Application No: FG/136/25/L
Site Address: Yew Tree Cottage 11 Ferring Street Ferring BN12 5HL
Description of works: Listed building consent to form a new vehicular access following the removal of gate and demolition of wall. (This application may affect the character and appearance of the Ferring Conservation Area).

Ferring Parish Council wishes to object to the proposed changes to Yew Tree Cottage.

PROPOSED NEW ENTRANCE & DRIVE TO YEW TREE COTTAGE, FERRING ST. BN12 5HL
 DRWG. NO. 11/01 JULY 2025

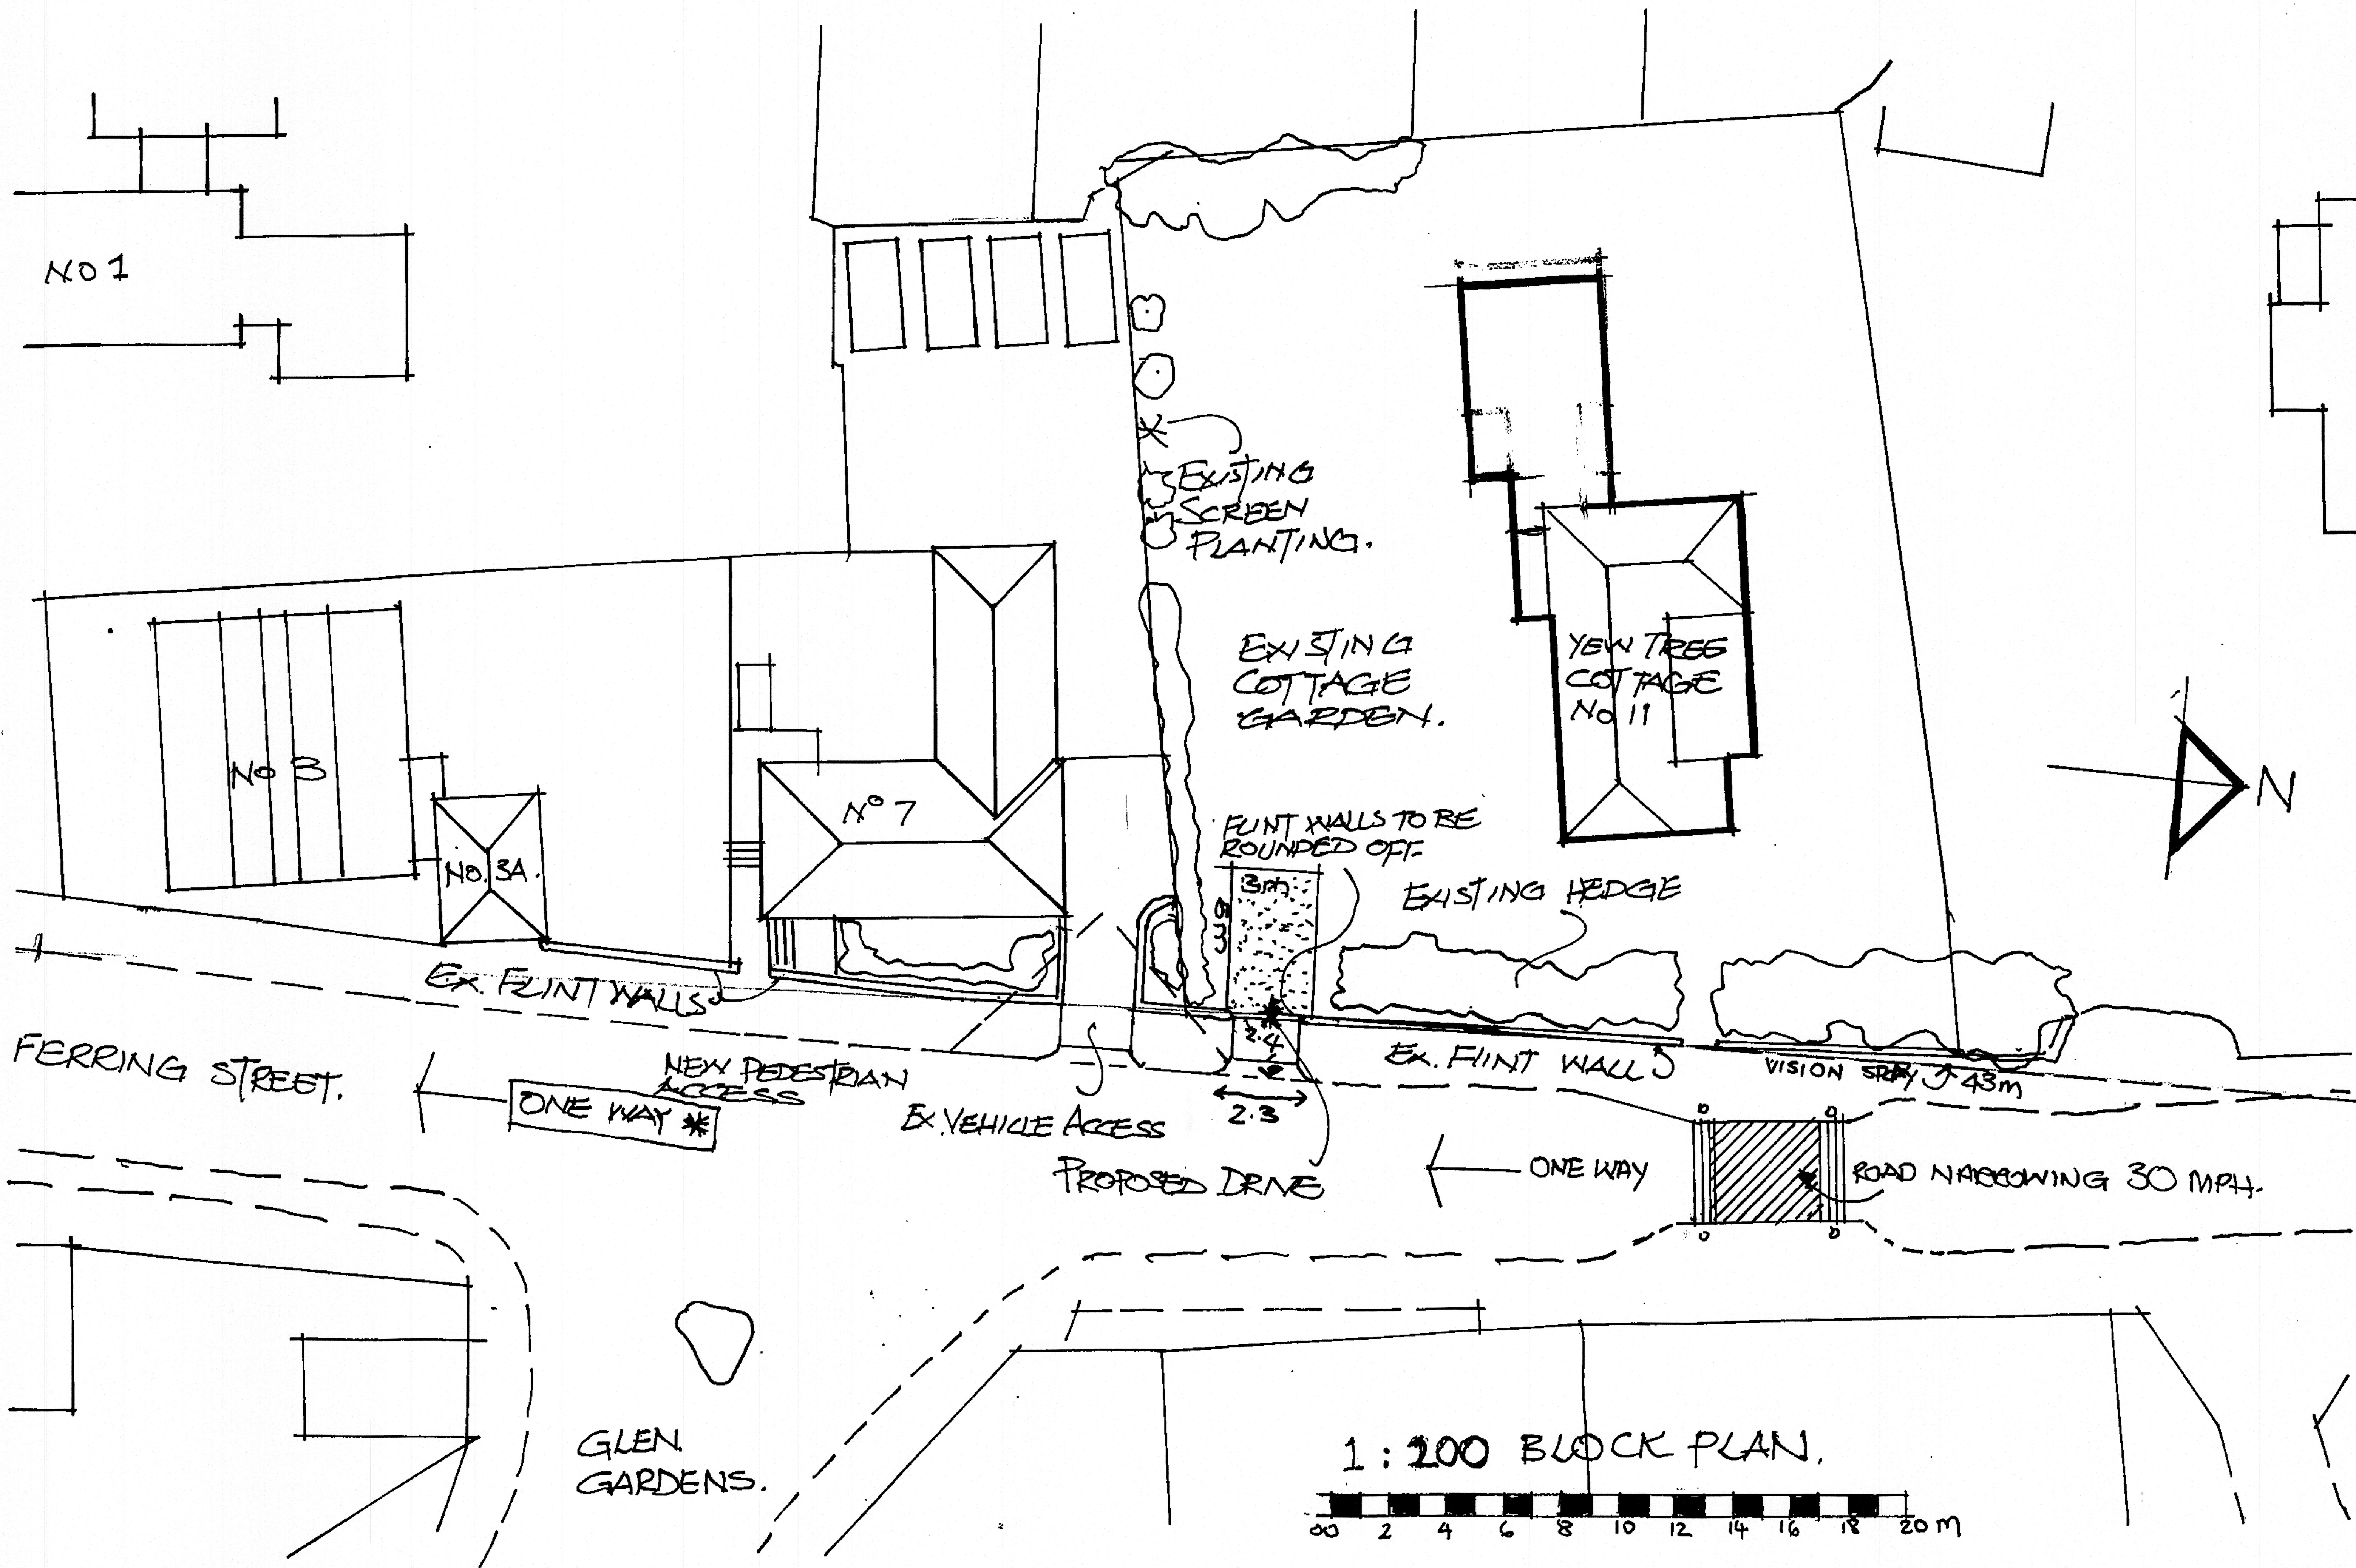
Although the proposal does not involve removing the entire flint wall, the Council is concerned that the works may compromise the structural stability of the remaining sections.

The demolition of part of this historic flint wall would significantly alter the setting of Yew Tree Cottage, harm the character and appearance of the Ferring Conservation Area, and would not be in keeping with the established street scene along this stretch of road.

The Council is also concerned that implementing the proposal may require the removal of nearby trees, further affecting the character of the area.
